**WEST SUSSEX COUNTY COUNCIL
PLANNING SERVICES CONSULTATION**

SUBJECT: LU/287/17/PL - Demolition of existing buildings, change of use & erection of 1 No. building incorporate office (B1) at ground floor & 8 No. dwellings at first floor level. Amendment received.

46a & 47, Pier Road & Land north of Clifton Road, Littlehampton, BN17 5LW

RECOMMENDATION: *No Objection*

drawing **Proposed site plan**

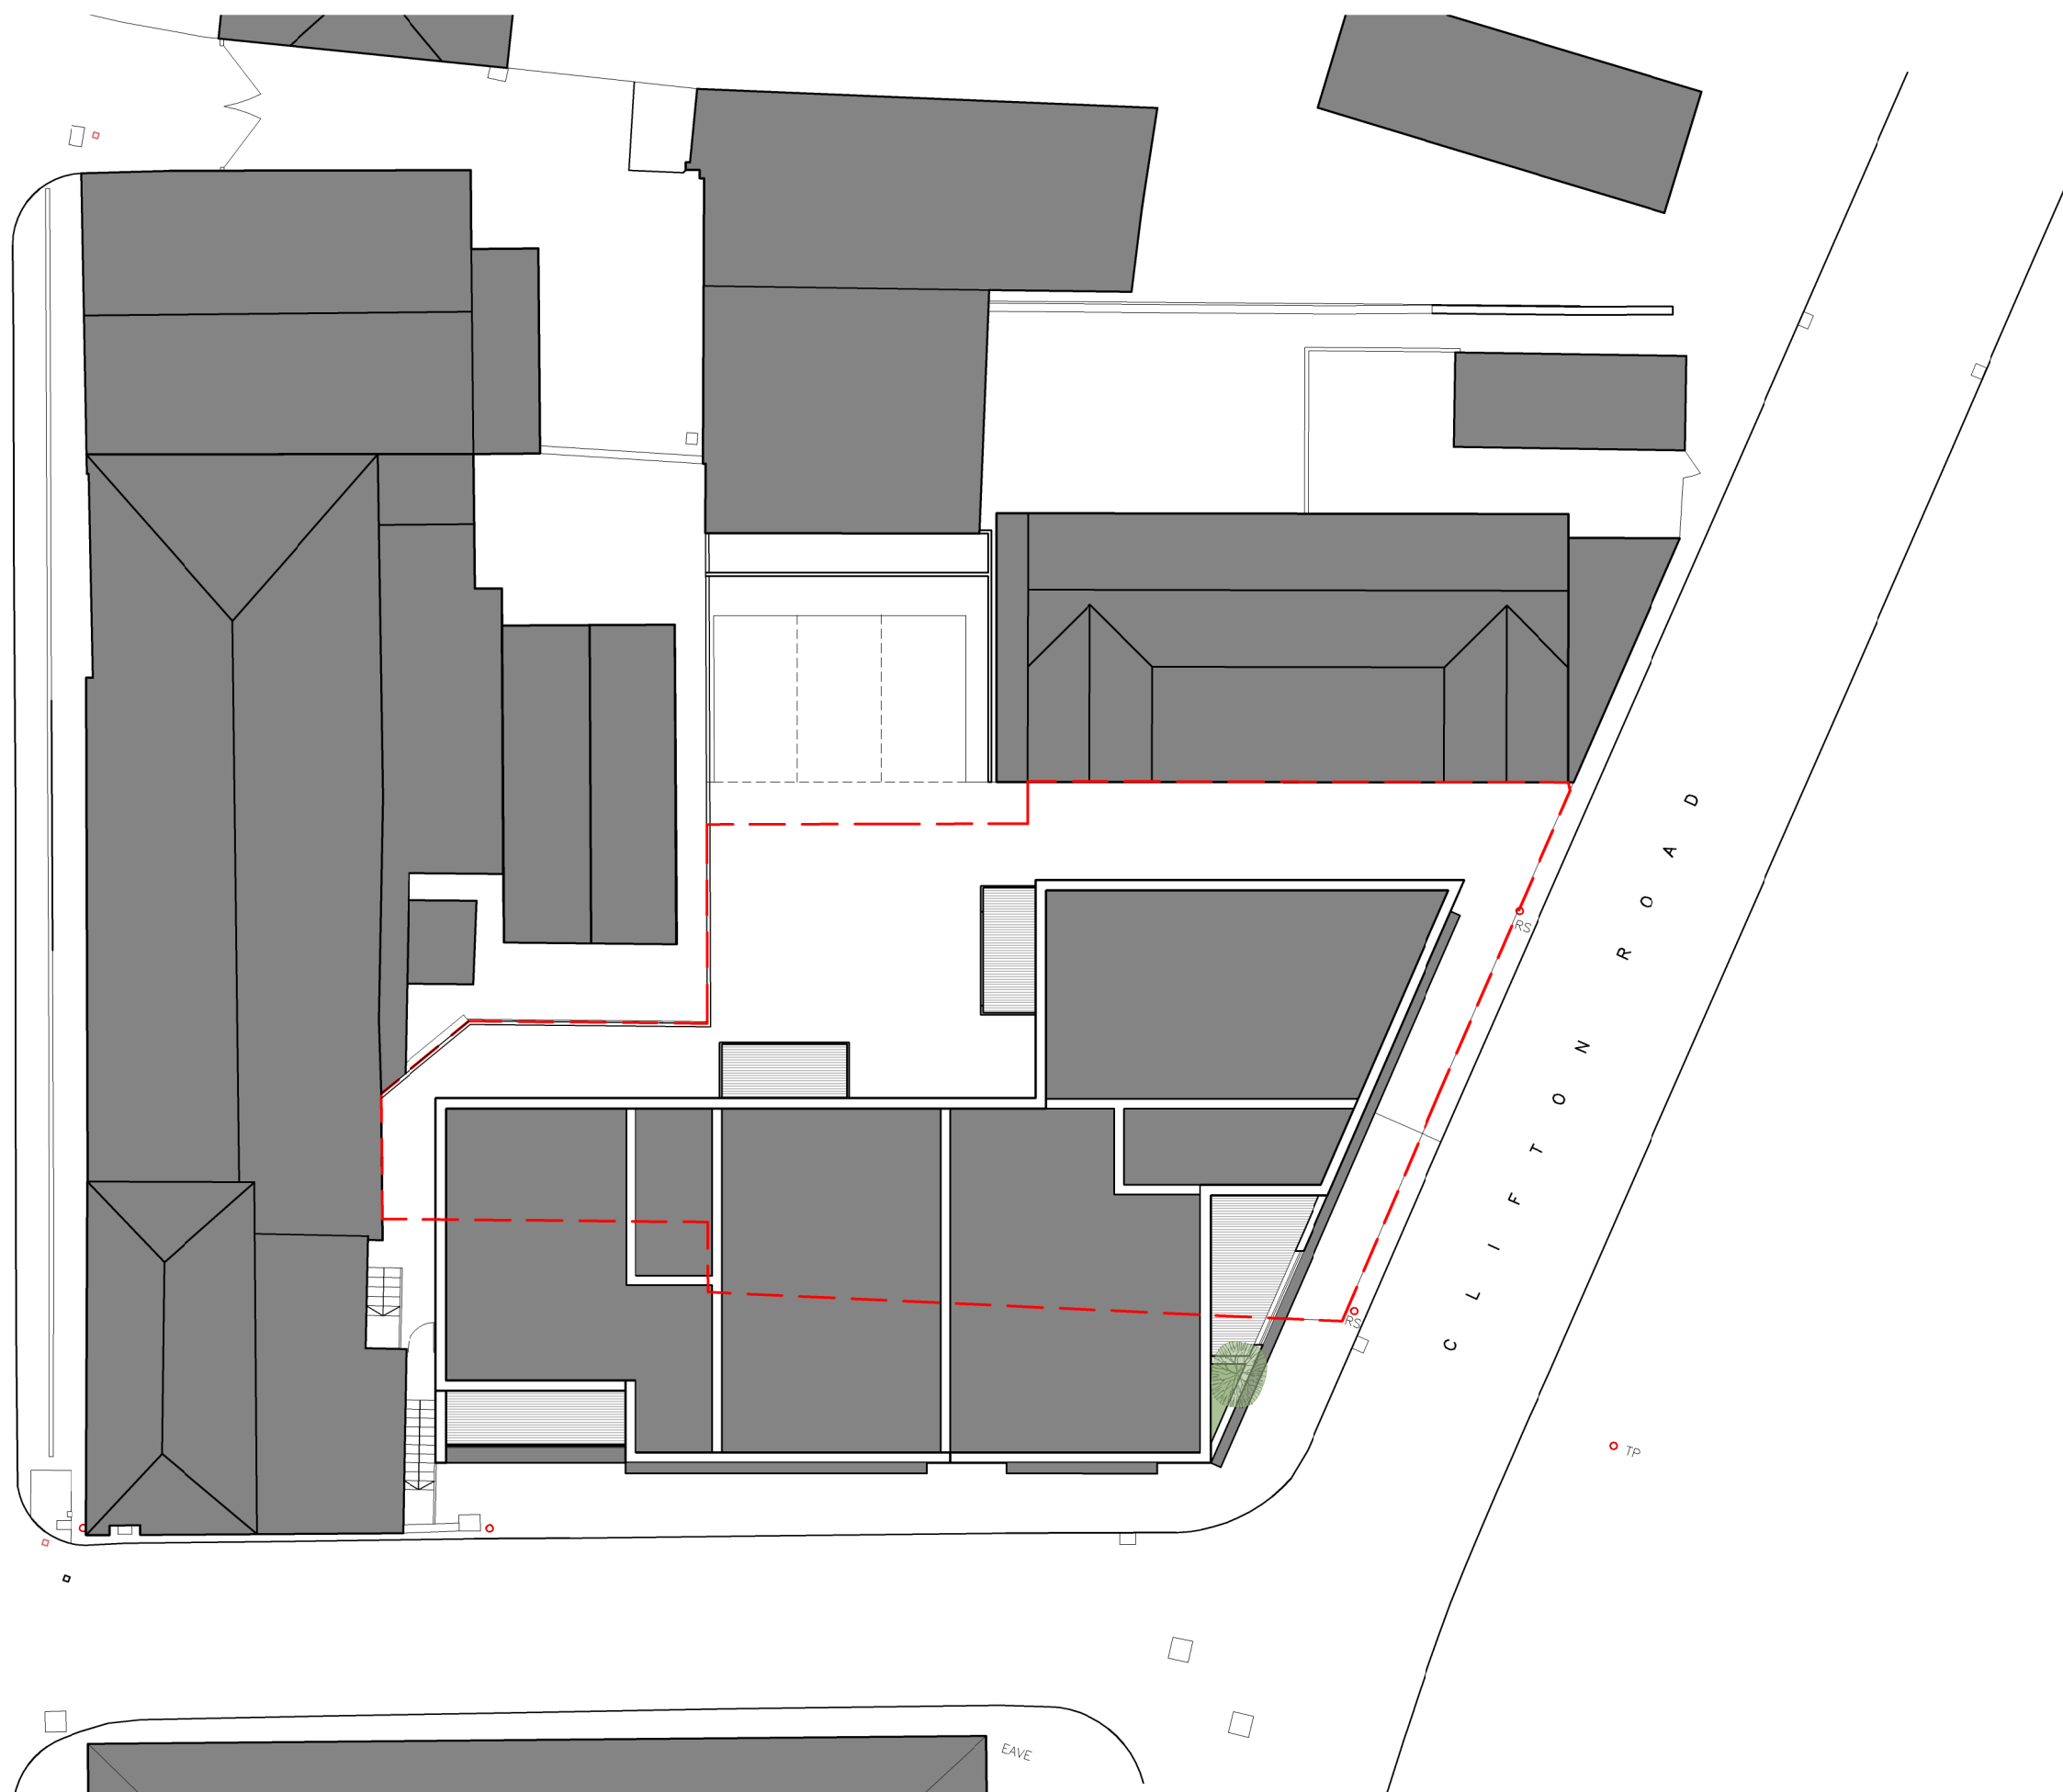
Some amended plans have been received that demonstrate a fixed bollard behind space 8 to prevent a car exiting on to Clifton Road in reverse, where visibility is restricted. This should be maintained in perpetuity and can be secured under a suitably worded condition. Space 7 and 8 will be allocated to a single flat and the remaining spaces of an unallocated arrangement. On this basis the WSCC Car Parking Demand Calculator envisions a total demand of eight spaces should be provided therefore the LHA are satisfied with the level of car parking provided for the flats.

The access has been widened at the entrance to 4.5m to allow two cars to pass. The access and footway works to the south and east elevations would require technical approval under a S278/38 Agreement with the WSCC Implementation team. This is to ensure that the access is built to a suitable specification and that the new footway is of sufficient standard to be adopted public highway.

Vehicle visibility splays have not been demonstrated. The LHA has considered the existing use at the site and number of vehicle movements that could take place currently via substandard accesses (garage doors abutting directly to the road). Vehicle movements are not anticipated to be severely increased over the existing and some improvement to visibility is provided by widening the access point and setting back the building line. The LHA also consider the slow speed and lightly trafficked nature of Clifton Road. In summary the combination of these factors would result in improvement over the existing parking, access and visibility and therefore no grounds to resist the proposals could be

substantiated. Furthermore, the formalised parking layout within the site now allows for a turn on site to exit onto Clifton Road in a forward gear.

No part of the development shall be first occupied until the car parking has been constructed in accordance with the approved site plan, including the fixed bollard as indicated on the *Proposed parking and access arrangements* plan. These spaces shall thereafter be retained at all times for their designated purpose.

No part of the development shall be first occupied until the vehicle turning space has been constructed within the site in accordance with the approved site plan. This space shall thereafter be retained at all times for their designated use.
